Project Name / File No.: Soper Hill Station (Permit #: PA22-030)
Applicant: Soper Hill Station, LLC
Project Description: Administrative Review – Site Plan
Site Address: 8907 Soper Hill Rd, Marysville
Review: Applicant's Response to (1st) Review

This letter serves as the Applicant's formal response to the 1st review comments received from the City of Marysville on August 19, 2022 to our recent application materials submitted to the city on July 5, 2022. To ensure that each of the comments have been responded to, we have incorporated each of the City's comments along with the Applicant's response to each below. The responses below are to inform you that we have addressed each of the City's comments so the review of the application may continue.

Sheet No.
 0000
 1.00

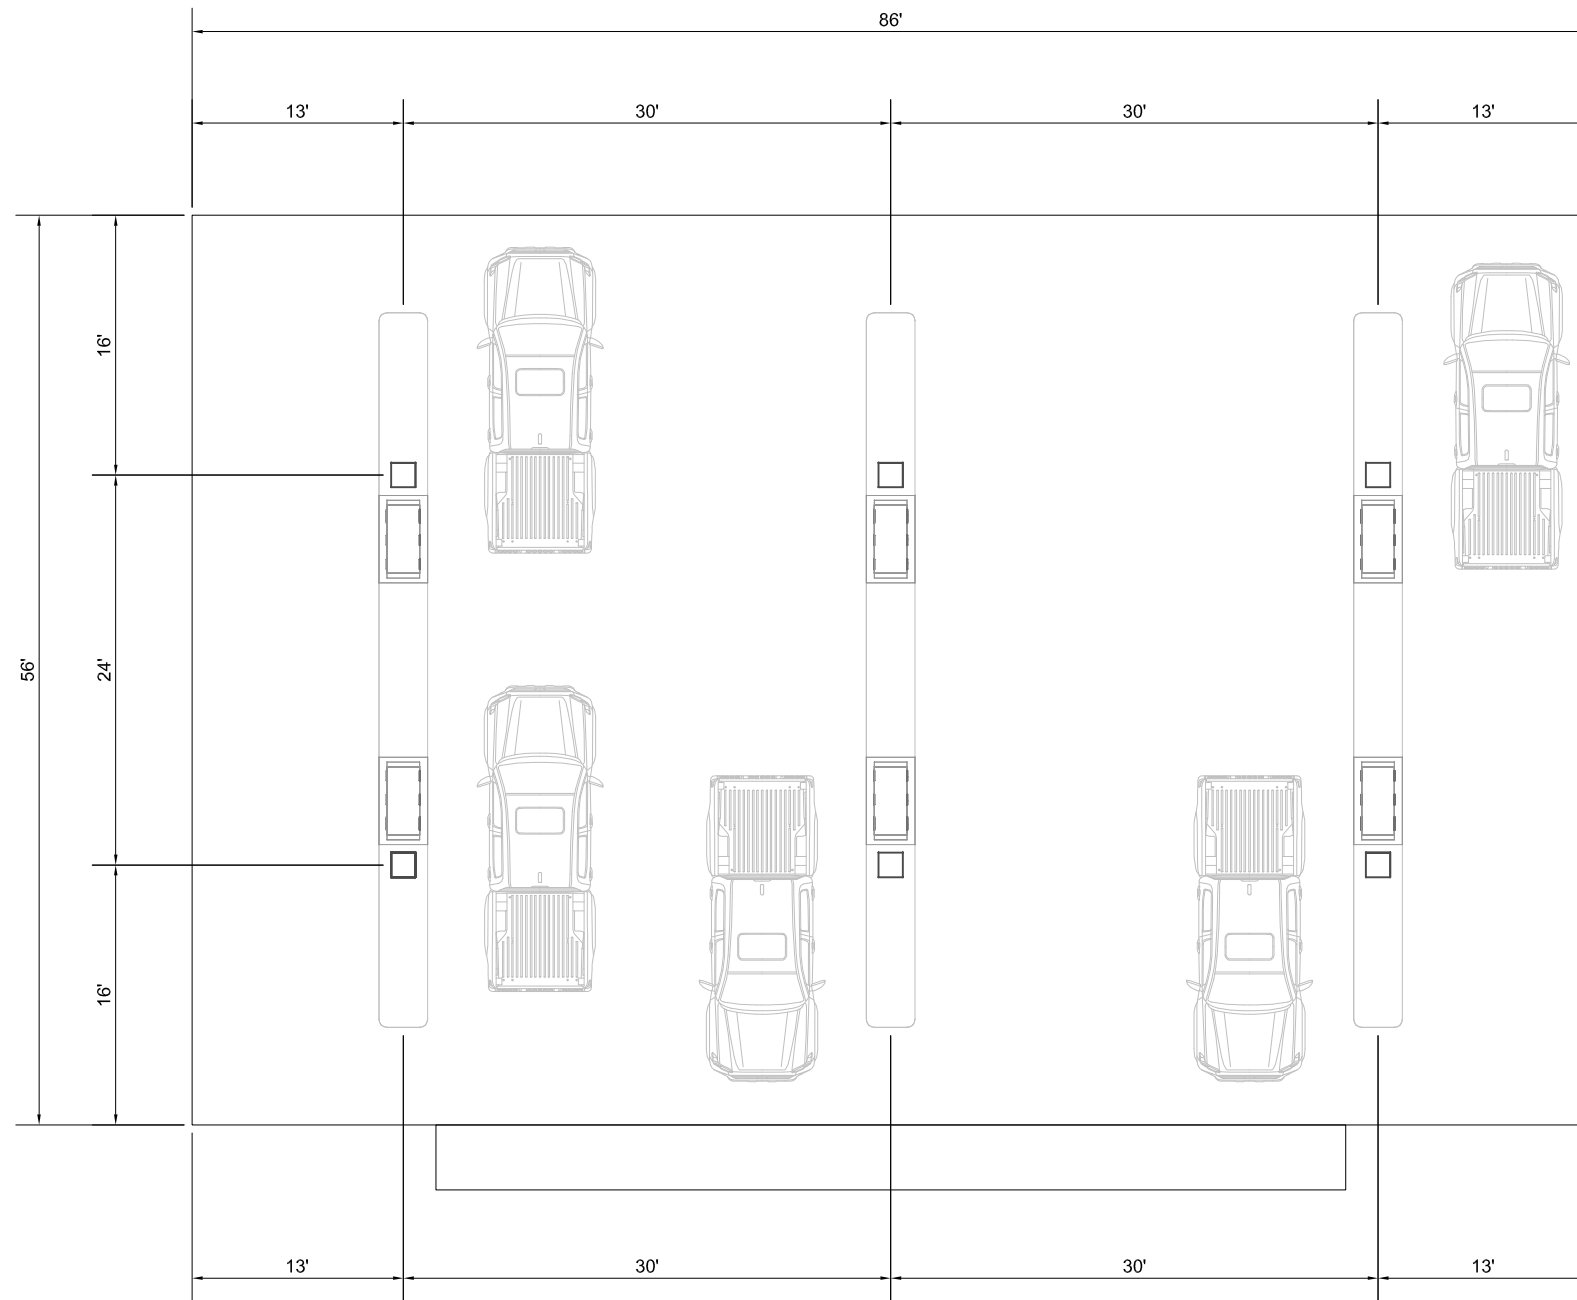
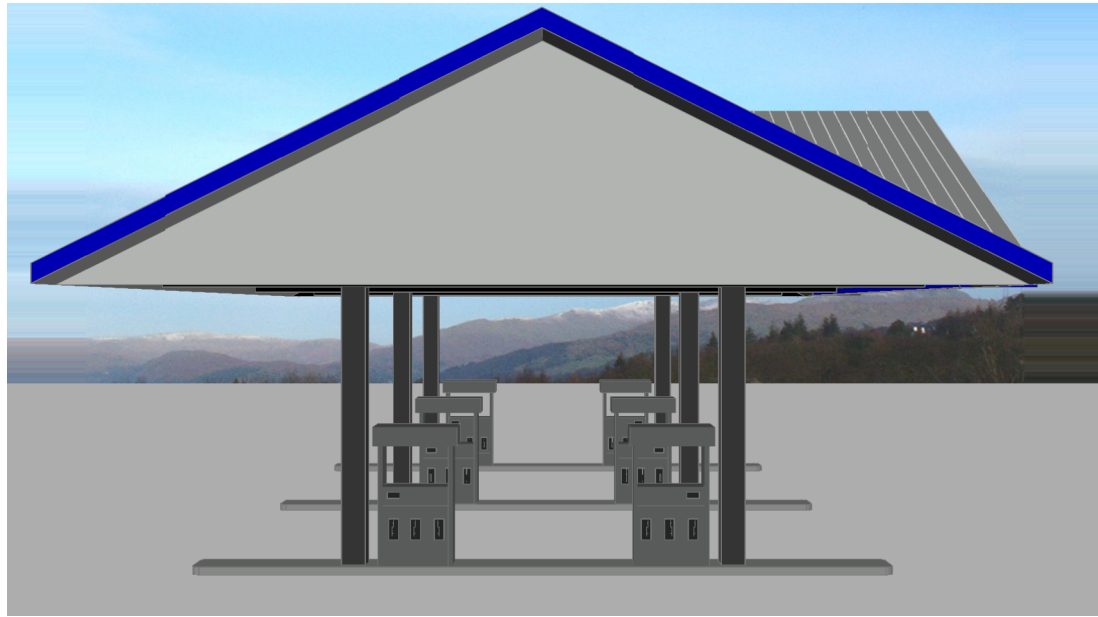
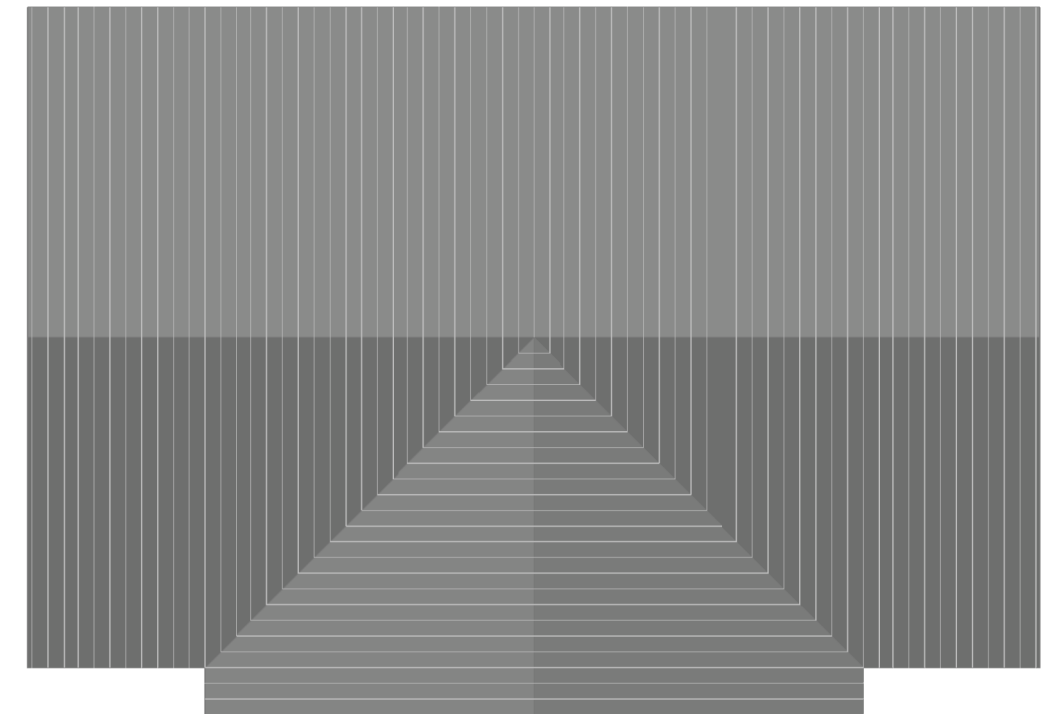
f. The Canopy Elevations provided do not appear to match the Exterior Material Board elevations provided. Additionally, the Canopy Elevations do not illustrate which elevation is the north, east, south and west. Please amend and the City will provide design review comments on the canopy.

Applicant's Response: Please see revised.

SP-02
SHEET 2 OF 2

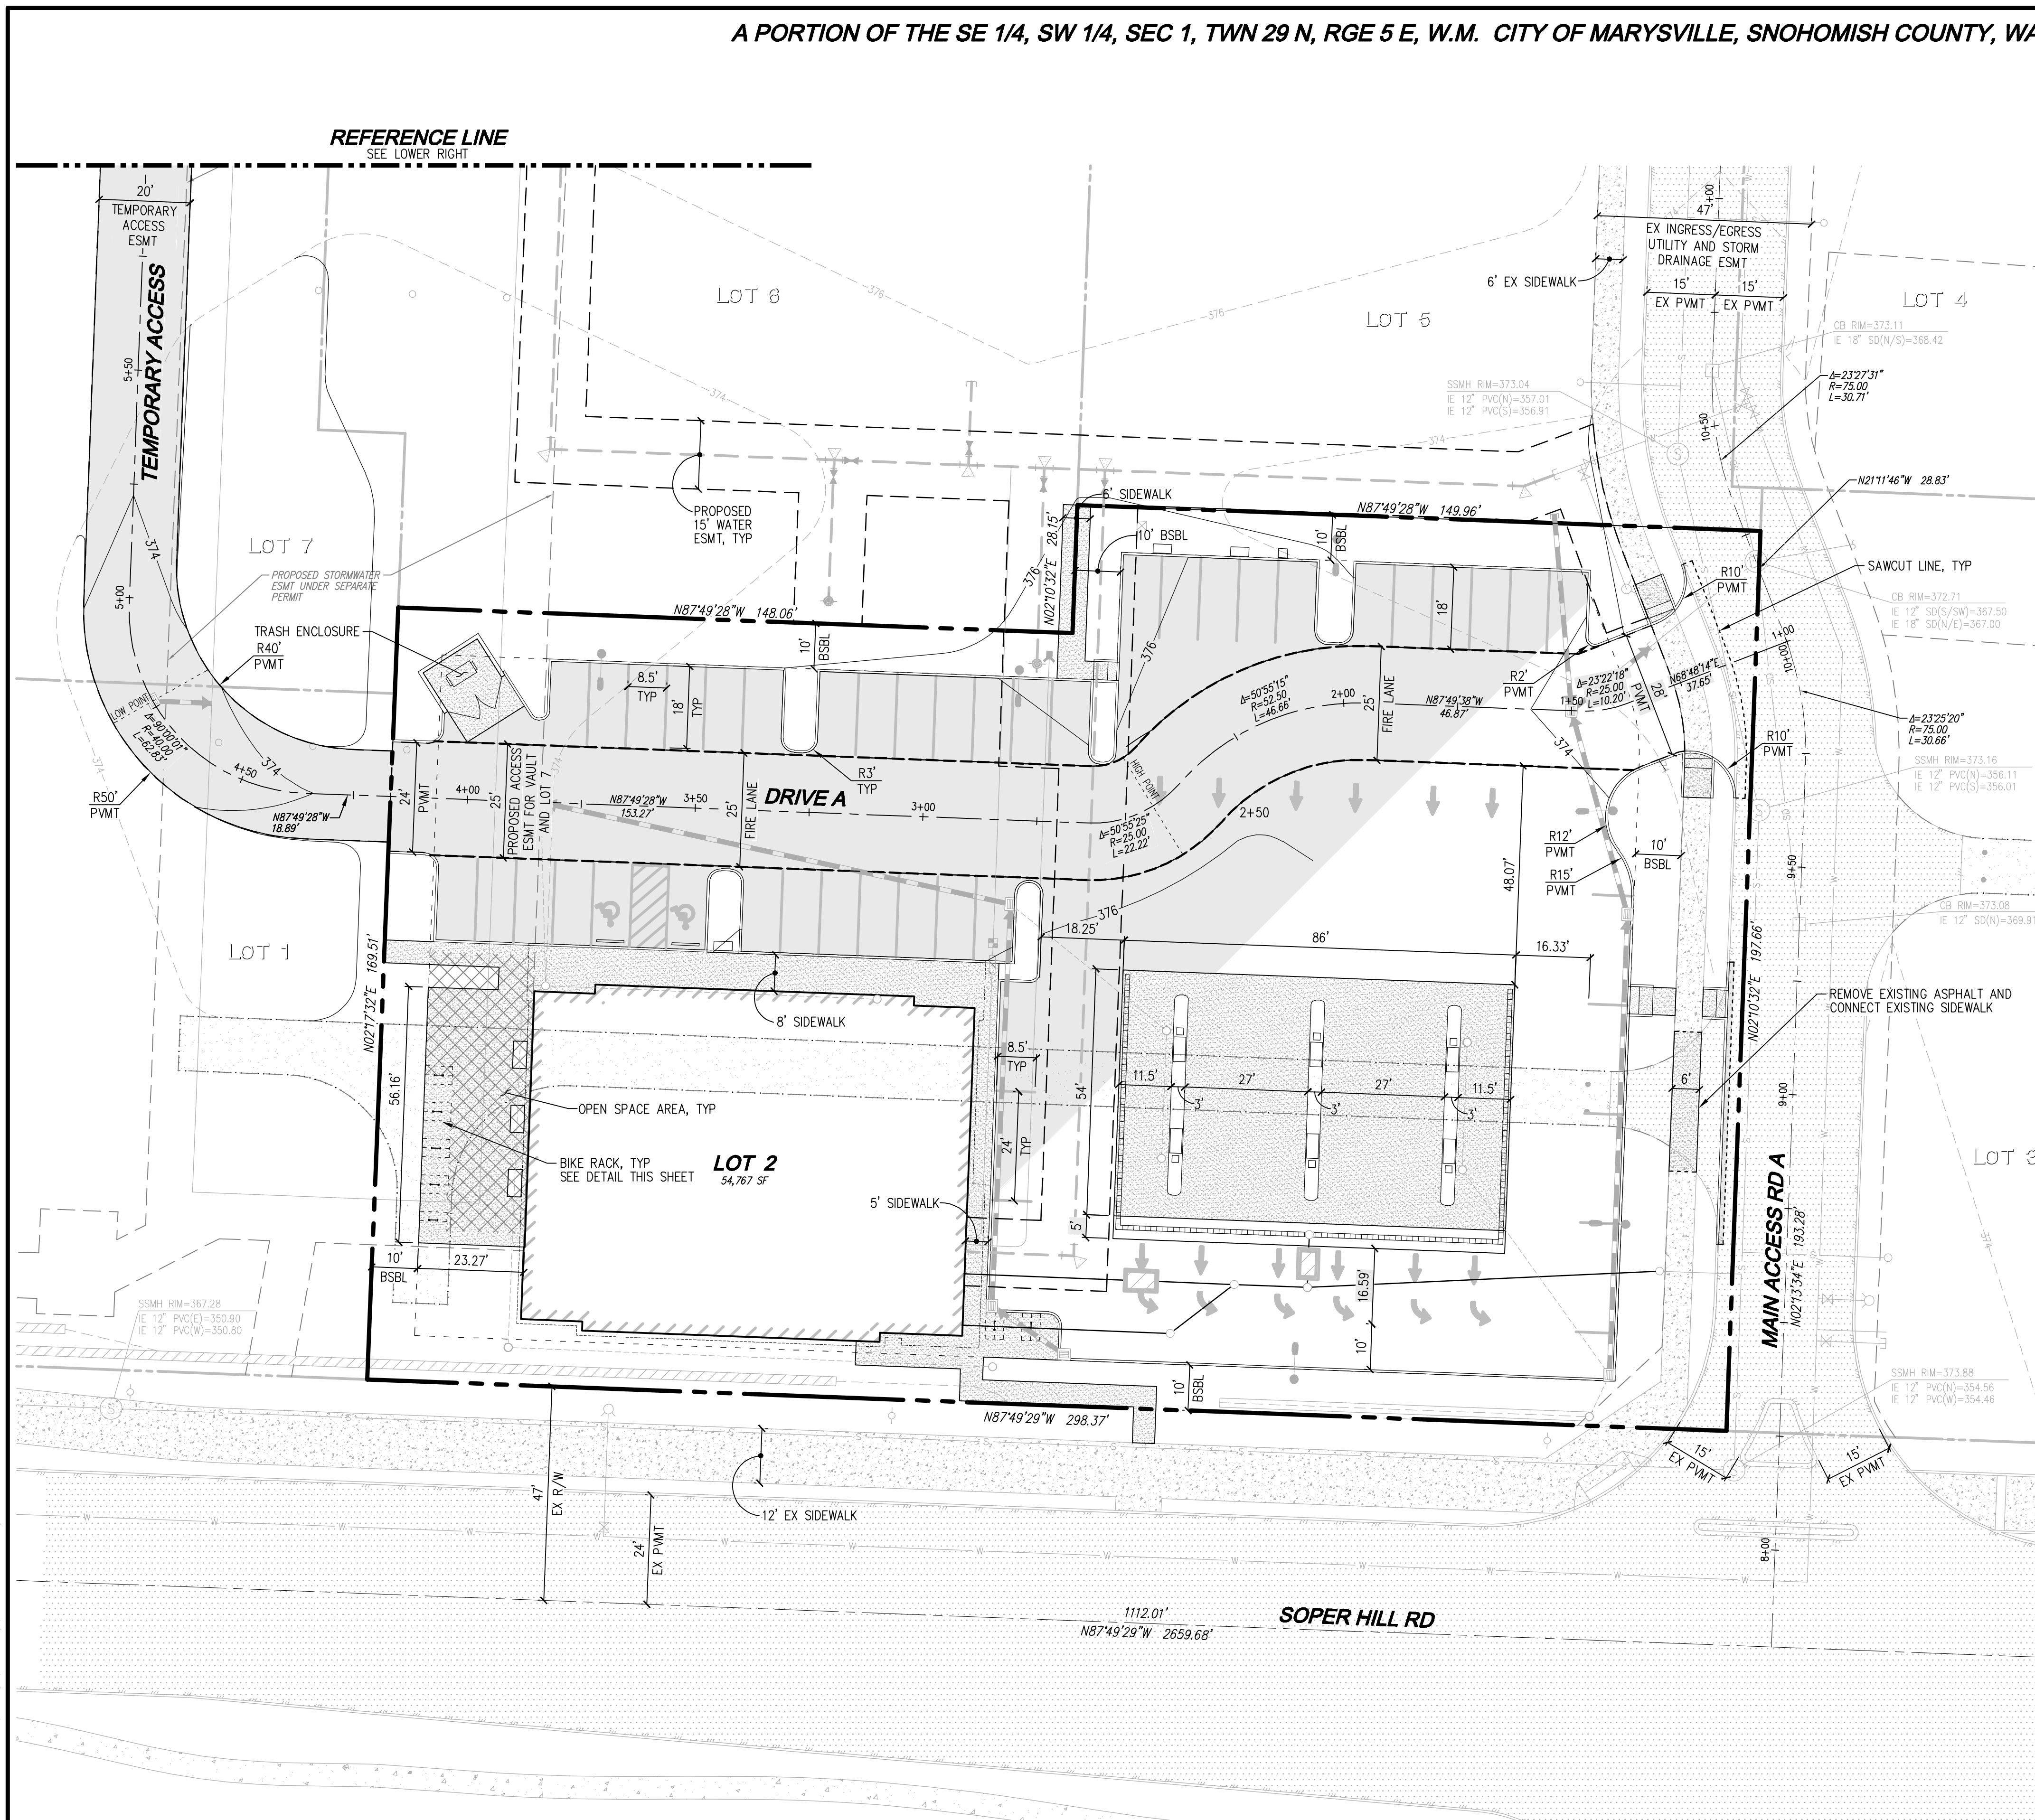
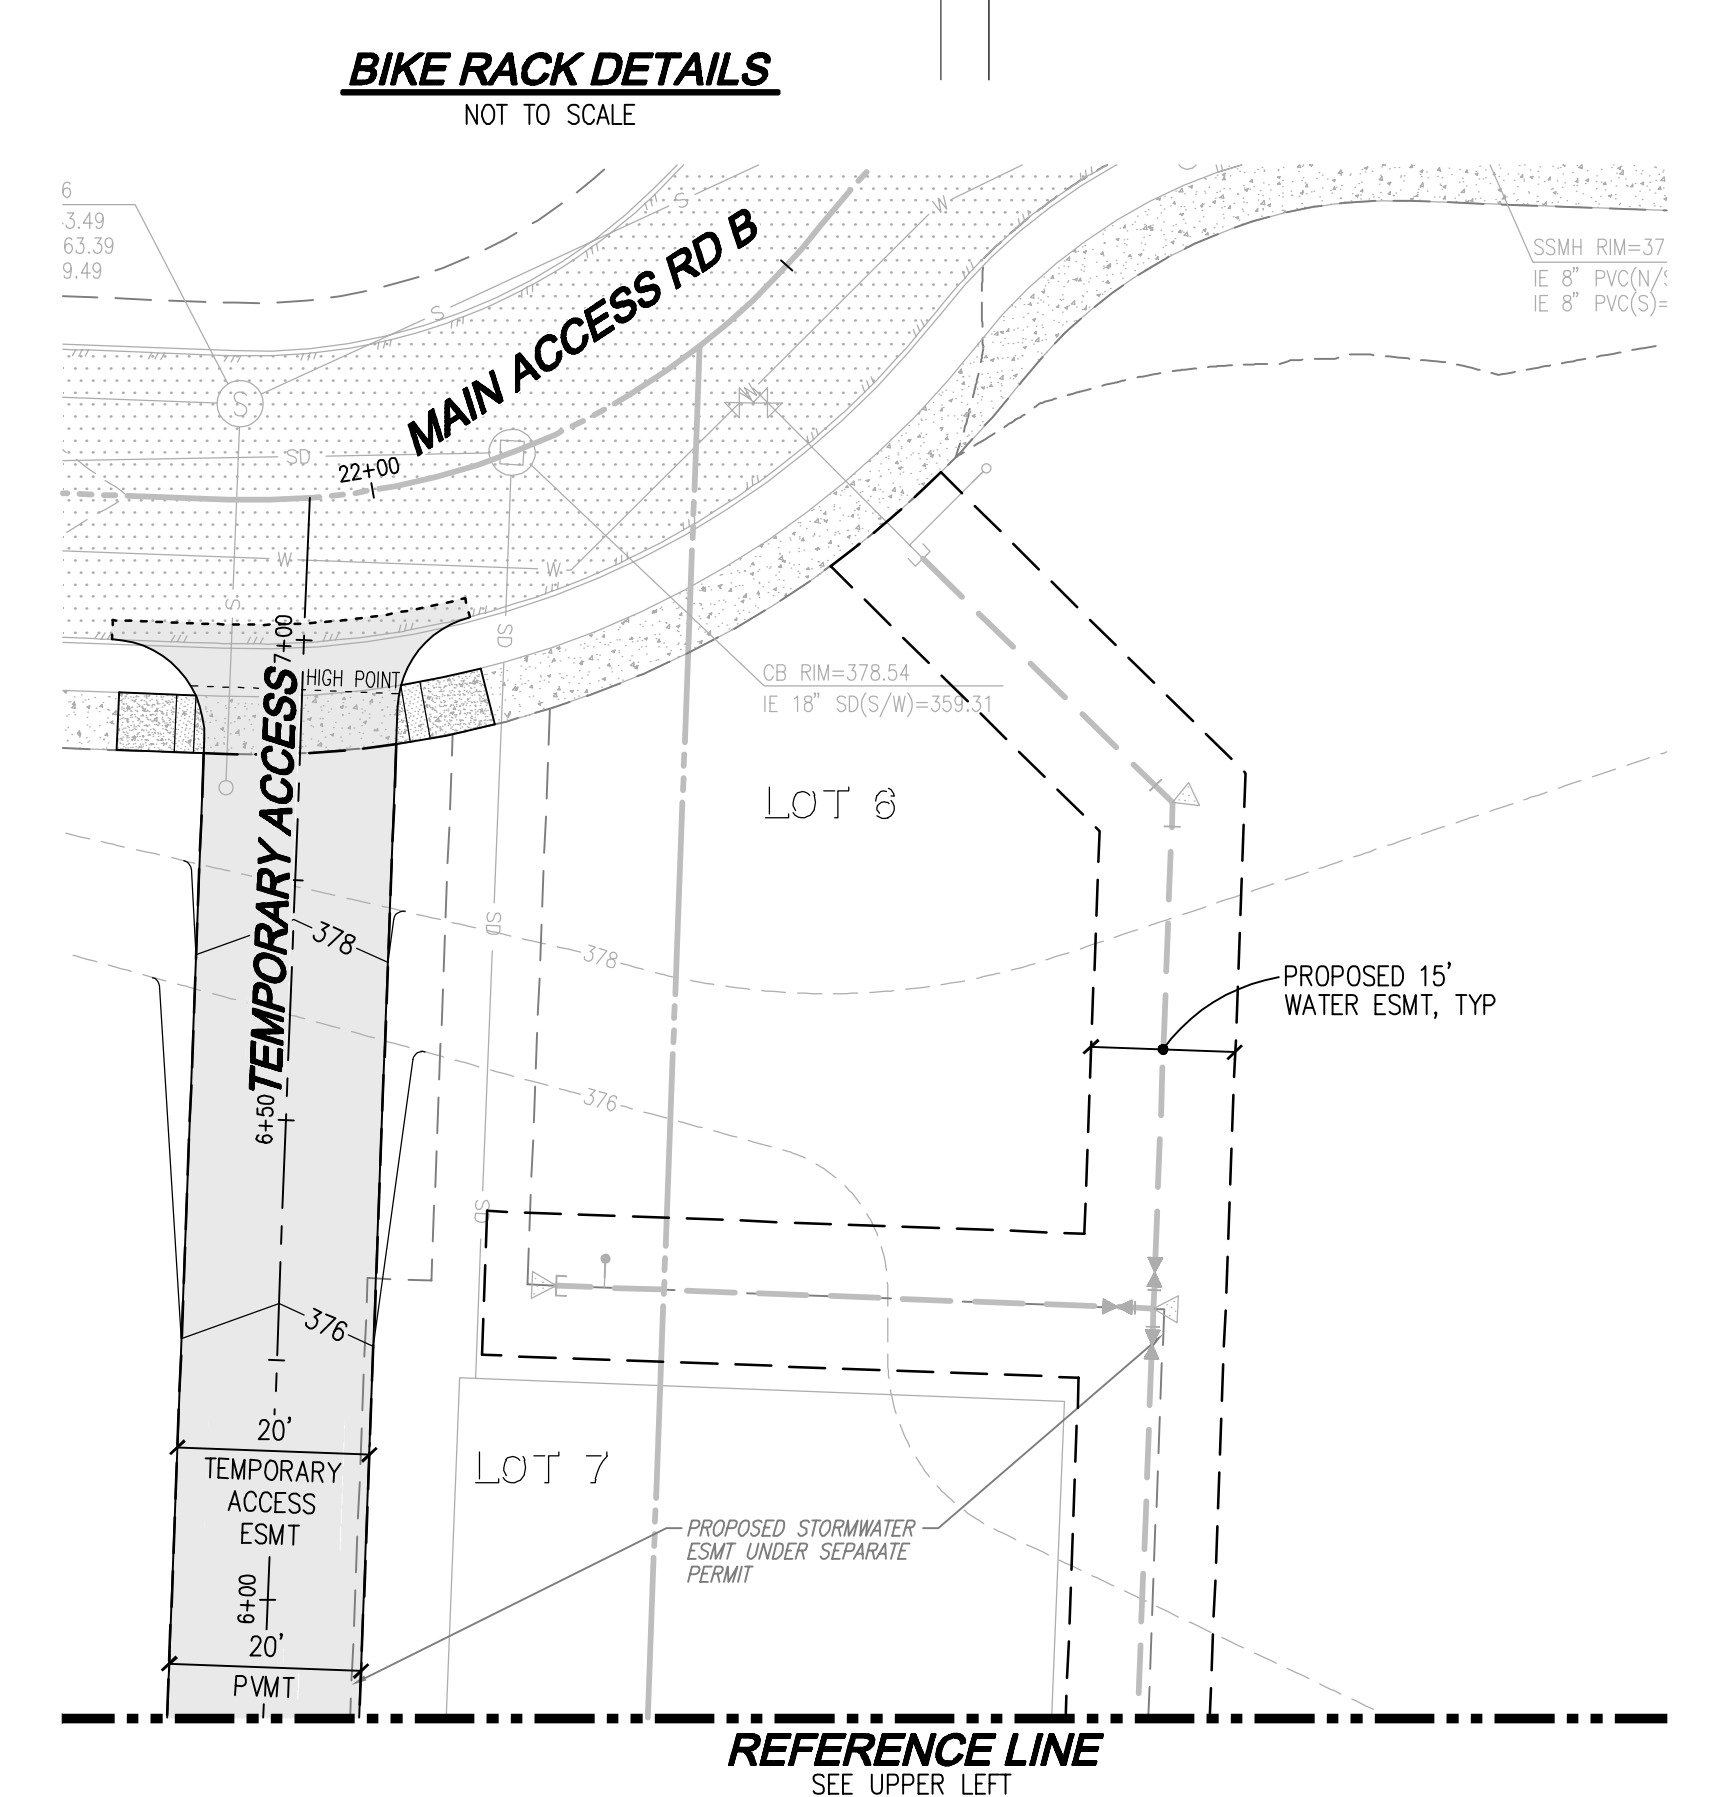
4. Amend Sheet SP-02, as follows:

a. Provide impervious surface calculations;

e. Amend the parking calculations to include building SF and math for calculating the required number of spaces, similar to the project narrative;

f. It appears that some of the proposed parking stalls measure 8' in width. 8.5' minimum required;

g. B.4.1.a. requires a side and rear setback of 15'. It appears the building is only setback 10' along the south property line

h. F.1.1 requires a 30' landscaping setback from Soper Hill Road and a 20' setback is required from Road A when a parking areas and drive aisles are located adjacent to these roadways. The Director may approve and condition reduced planter widths provided the design meets the intent of the standards and guidelines. For example, reduced widths may be allowed provided the landscaped area is supplemented with architectural features that help to define the street edge and maintain visual continuity along the street. Examples could include a decorative low wall made of stone or masonry that is used in conjunction with landscaping, and/or use of a landscaped trellis or architectural columns. For each method, it is important to maintain visibility at eye level (between 3 and 8 feet above the ground) between the street into the parking lot for safety.

i. F.2.4.a. requires service elements (i.e. solid waste disposal areas) to be located to minimize the negative visual, noise, odor, and physical impacts of the street environment, adjacent (on and off-site) residents or other uses, and pedestrian areas. The proposed location of the solid waste collection area will need to be relocated so that it is not visible upon entry into the site.

j. A minimum 5' L4 landscape buffer is required at the end of the row of parking on the northeast portion of the parking area.

Applicant's Response: Impervious surface areas have been included on the sheet indicated.

Applicant's Response: Parking calculations have been amended, calculations match between civil and architectural plans.

Applicant's Response: All stalls are drafted correctly with 8.5-foot minimum width, measurements indicated on redlined plans may be a result of an inaccurately scaled or poorly scanned PDF drawing.

Applicant's Response: Building has been adjusted to provide appropriate setbacks from property lines and overhead wire.

Applicant's Response: Per our previous conversation a Type L3 10-foot buffer has been provided along both Drive Aisle A and Soper Hill Rd. In addition, landscaping will be provided in the 5-foot planter strips between Soper Hill Rd and Drive Aisle A.

Applicant's Response: Garbage area has been relocated and screened.

Applicant's Response: This has been provided.
